Ribble Valley Borough Council
Housing & Development Control

Application no: **3/2022/0096**

Address: **Gisburn Auction Mart Gisburn Lancashire BB7 4ES**

Proposal: **Demolition of former calf building, offices and retail units and construction of new building split into two units**

Drawing Block/Site Plan

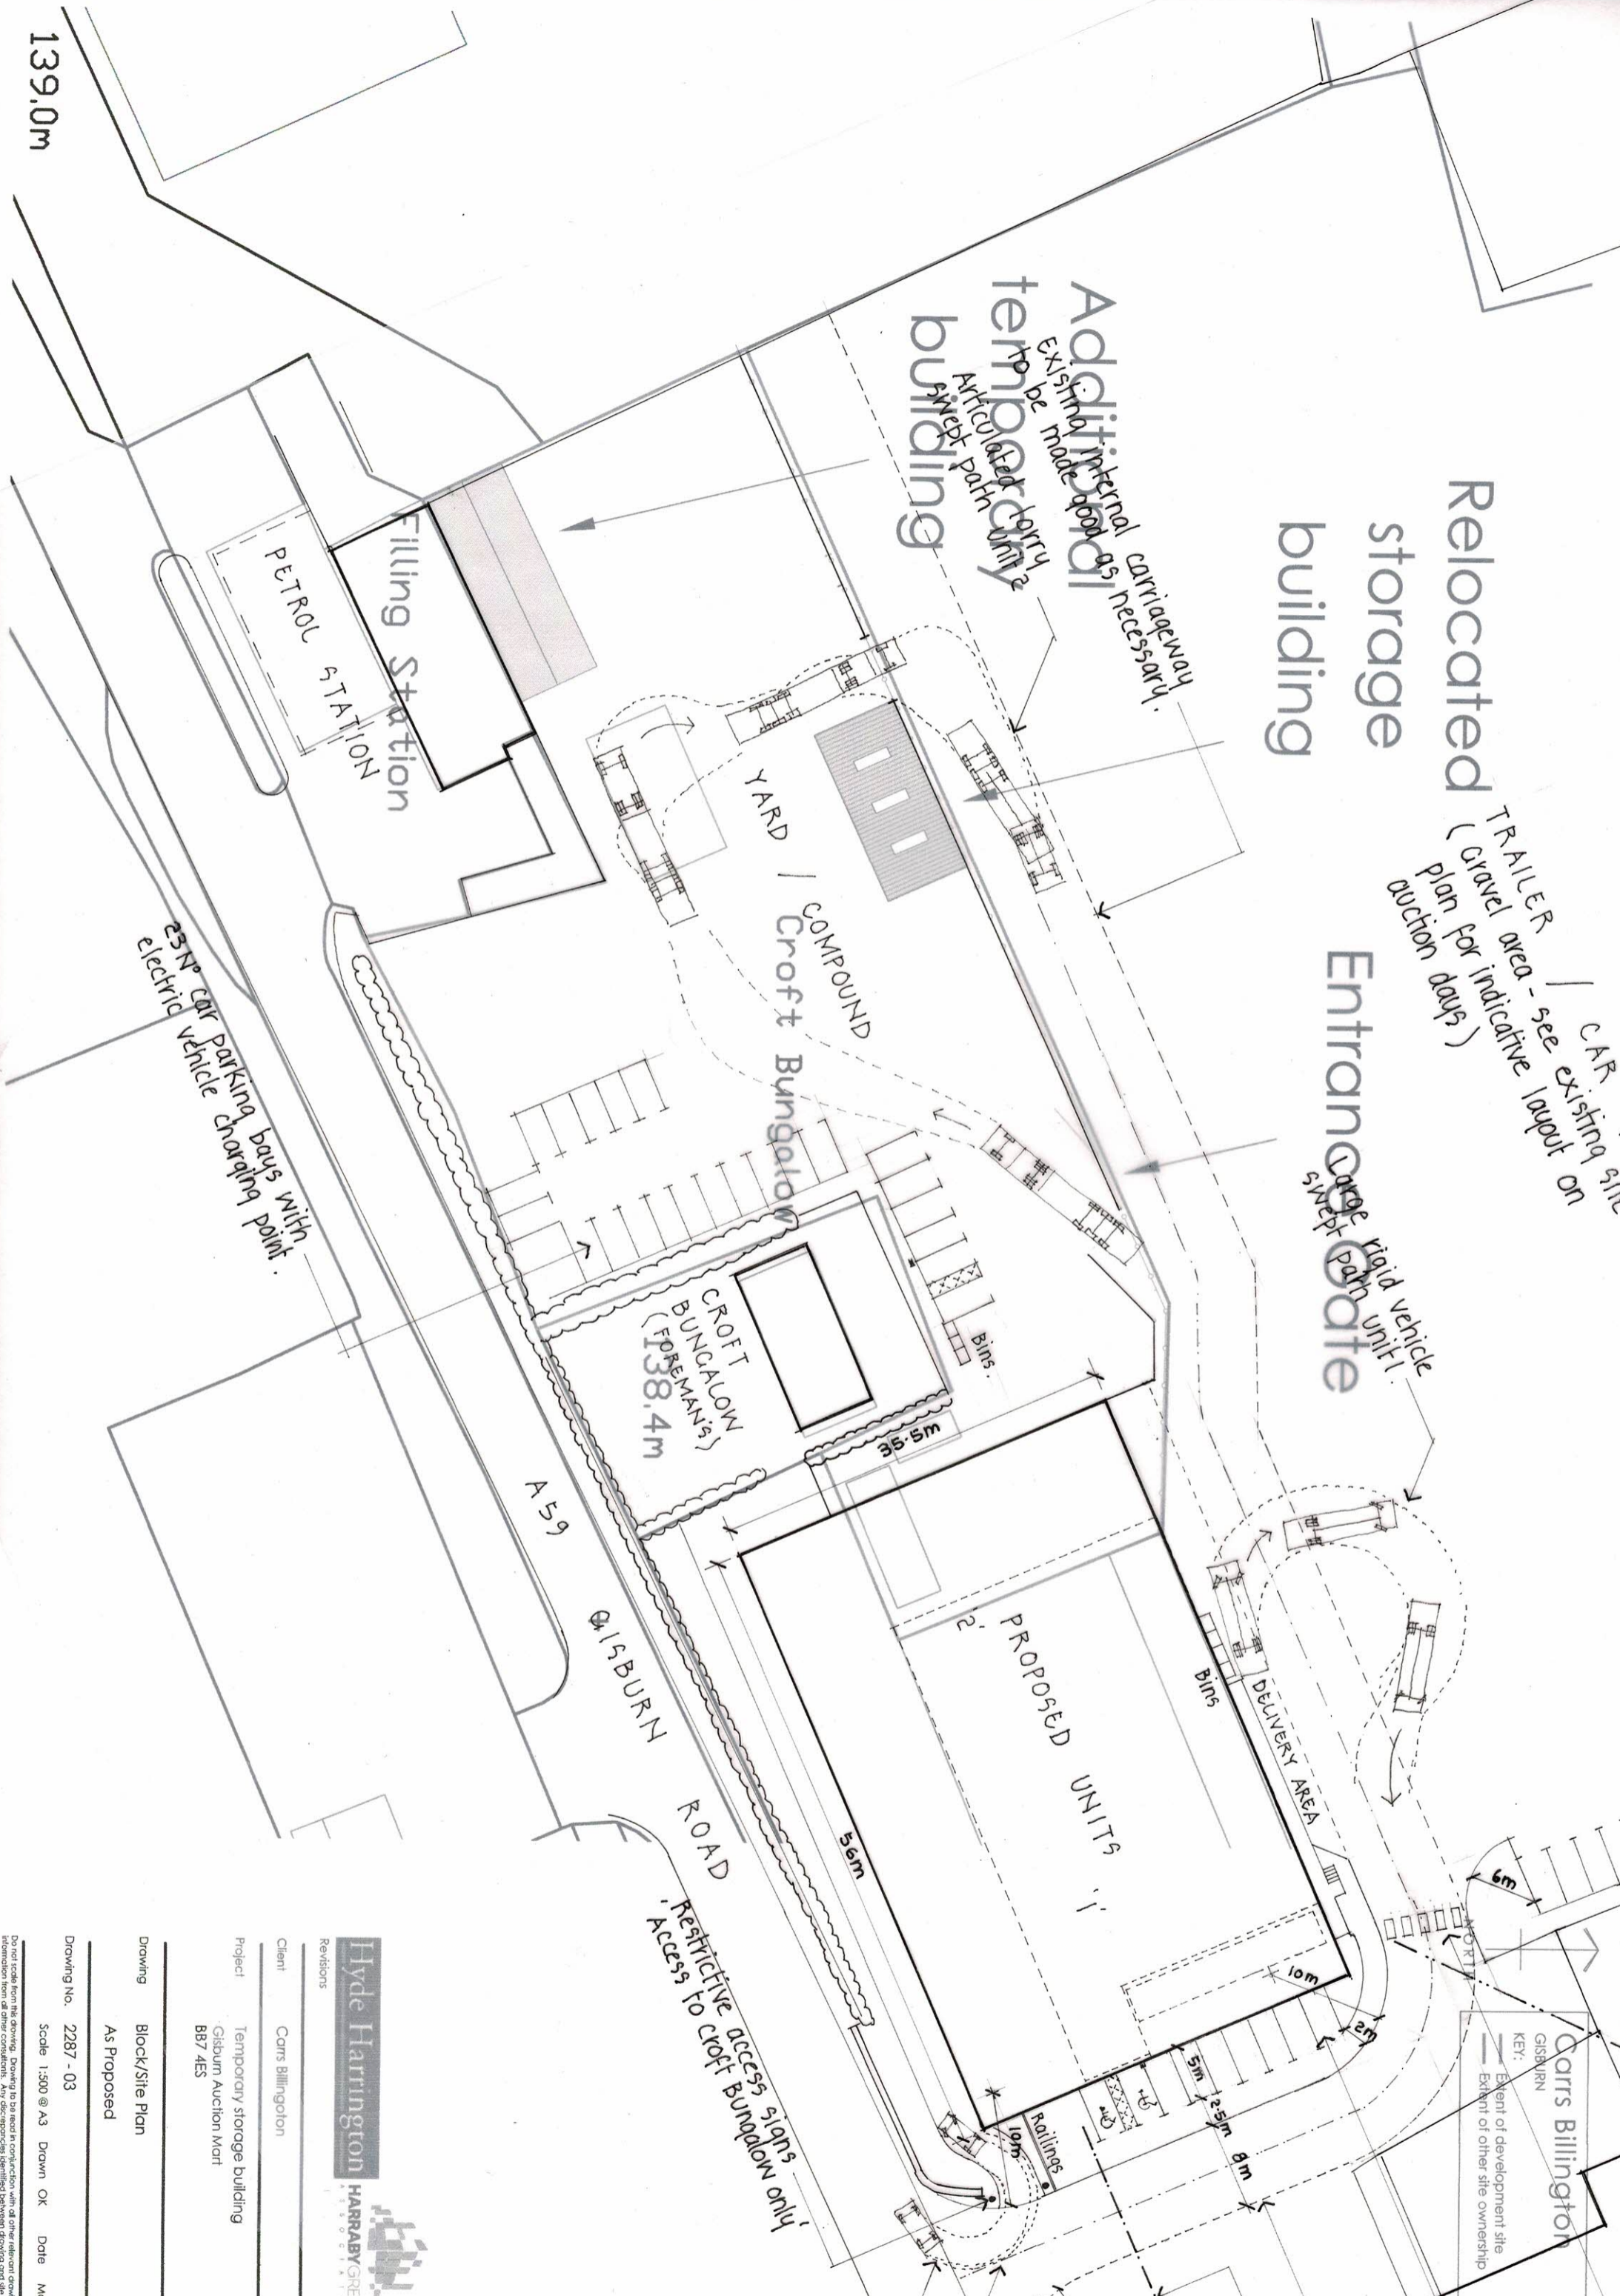
Therefore, the LHA require the access to the dwelling to be relocated through the site and the Units to be setback a few metres closer to the public highway, to prevent vehicles from accessing down the side of the proposal. This should be shown on a revised drawing.

The LHA have reviewed ADP drawing number 645/13 titled "Proposed Site Plan" and the supporting documents and understands that the site will provide 166 spaces for the proposal. However, the LHA would require the site to provide 169 spaces given the internal floor area of the A1 proposal.

The LHA have also reviewed the dimensions of the parking spaces for Unit 1 and are aware that the length of the spaces only measure 4.5m. For the LHA to accept a parking space, the LHA require the length of the spaces to be a minimum of 4.8m. Therefore, the length of these spaces should be amended on a revised plan.

Furthermore, the spaces for Unit 1 which are located at the front of the site adjacent to the site access, only has space of approximately 1.6m between the front of the bay and the internal carriageway, when the dimensions of the spaces are drawn correctly. The LHA are concerned that this segregated space between the bays and the carriageway is too narrow for pedestrian movements to occur when accessing the unit. This could cause some pedestrians to walk in the internal carriageway, especially when a customer is operating their cars boot, which could be detrimental to highway safety given that large, agricultural vehicles use the access and given the intensification of use following the proposal. Therefore, the LHA require the segregated space between the bays and the carriageway to be a minimum of 2.5m to enable pedestrian movements to occur safely.

The LHA have further reviewed the site and require the Cattle Auctions car park and the internal carriageway to become more formalised and incorporate segregated pedestrian movements to the proposal. This is because the proposal will generate more trips to the site and so the car park will be used more frequently, should the designated car parking spaces be full to capacity. Therefore, to provide a safe, segregated pedestrian link to the Units, the LHA require there to be a distinction between carriageway and footway throughout the site.

To ensure that the formalised carriageway, which should be shown on a revised plan, is safe and usable for the sites use, the LHA require a swept path analysis drawing to be submitted showing a refuse vehicle entering and exiting the site as well as using the internal carriageway.

The swept path drawing should also show that a servicing area is provided for both units, with there being no facilities on the drawing for deliveries and that turning facilities for these vehicles are provided at the site.

To further formalise the car park, the LHA would advise that the trailer spaces and the car parking spaces are located in designated areas and are marked on a revised plan. The need to separate the car parking spaces and the trailer spaces will be particularly important during Auction days, when the demand for trailer spaces will be high. Therefore, to enable an easy distinction between trailer spaces and car parking spaces for visitors to the site, they should be located in designated areas.

DRAWING TITLE  
PLANNING  
PROPOSED FIRST FLOOR PLAN

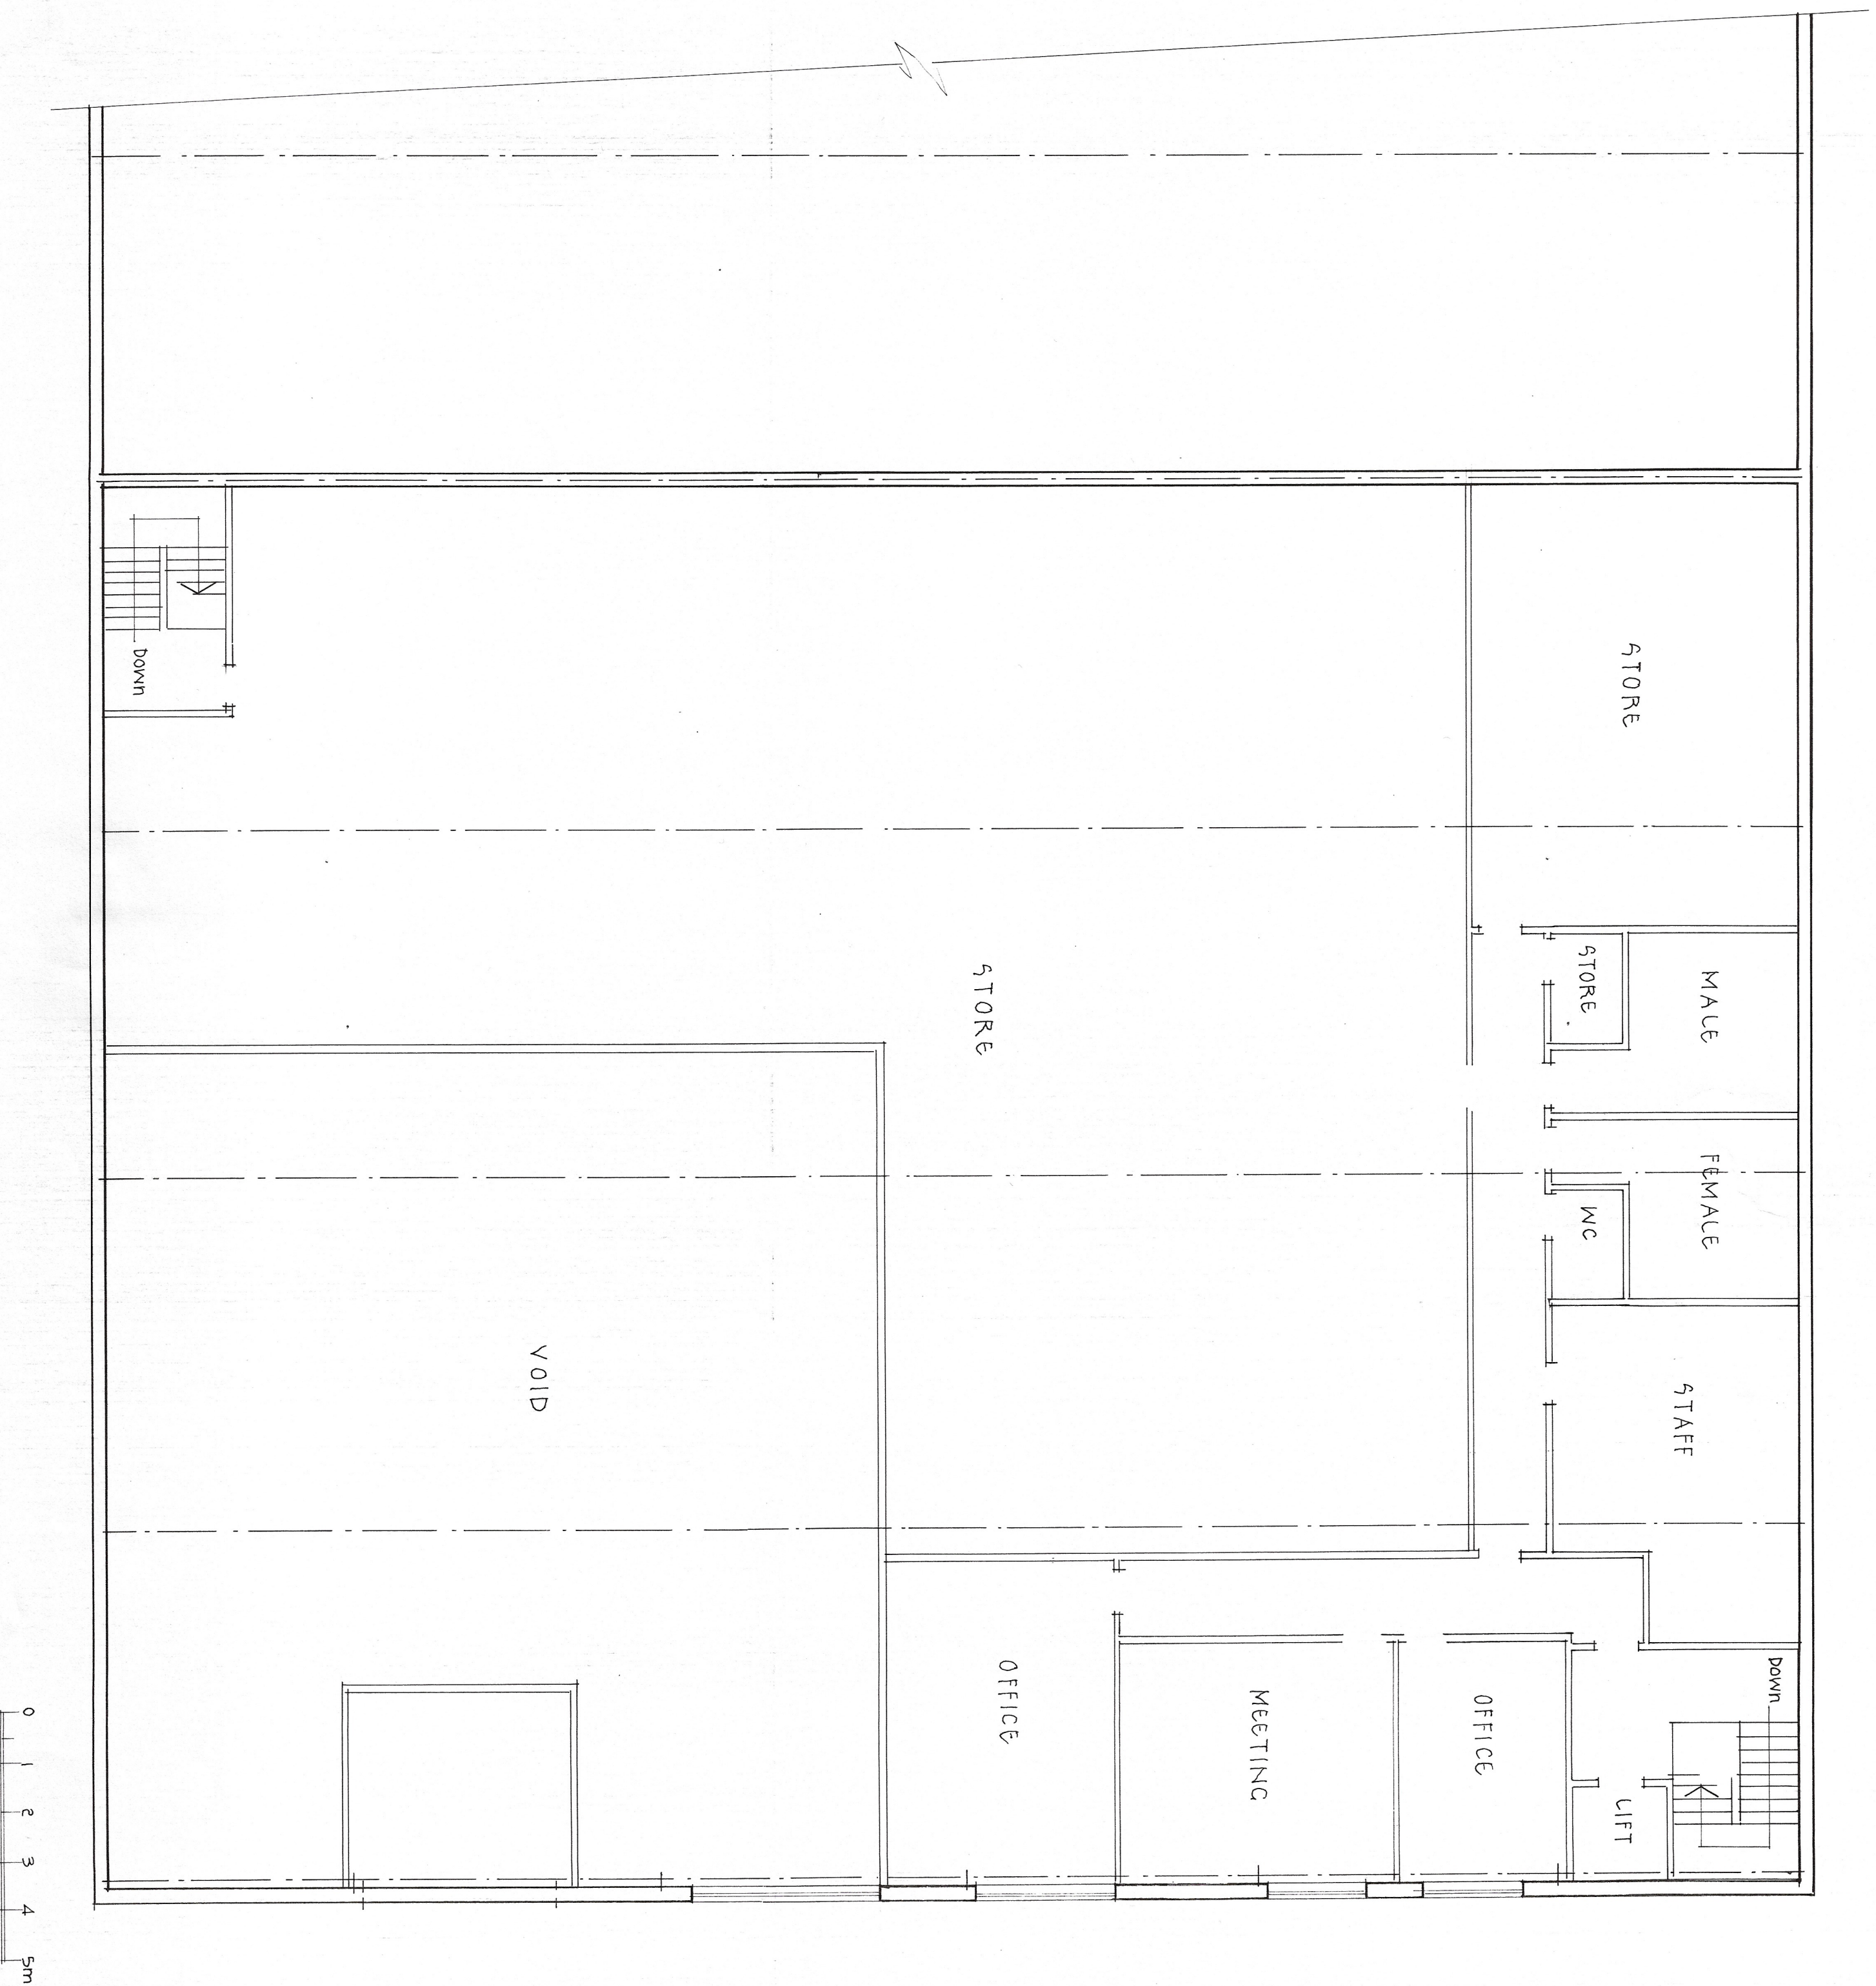
The LHA also request that further information is submitted regarding the "ancillary accommodation for Unit 1" which is stated in the Design Statement. This is because on the floor plans there is no suggestion of ancillary accommodation.
